STATE OF NORTH CAROLINA
DEPARTMENT OF TRANSPORTATION

Addendum No. 1

RE: Contract ID C202852
WBS # 7CR.10011.32, Etc.
State Funded

1 Section of US-70, 1 Section of NC-62, 2 Sections of NC-87, 1 Section of NC-87/100
And 1 Section of Secondary Road

TYPICAL SECTION NO. 5
TO BE USED ON MAP 4
STA. 0+00 TO STA. 55+80
STA. 63+55 TO STA. 95+00

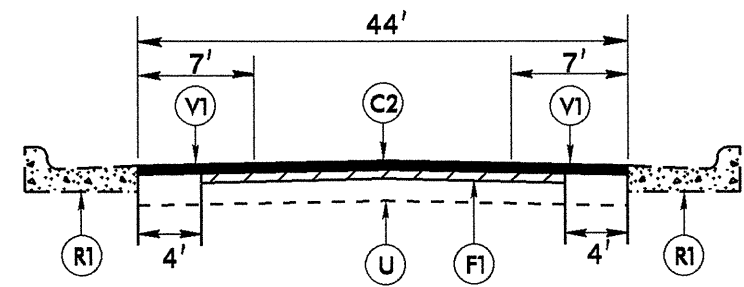
On Sheet No. 3, Typical Section No. 5 was modified to indicate "C1" surface course. Please void Sheet No. 3 in your plans and staple the revised Sheet No. 3 thereto.
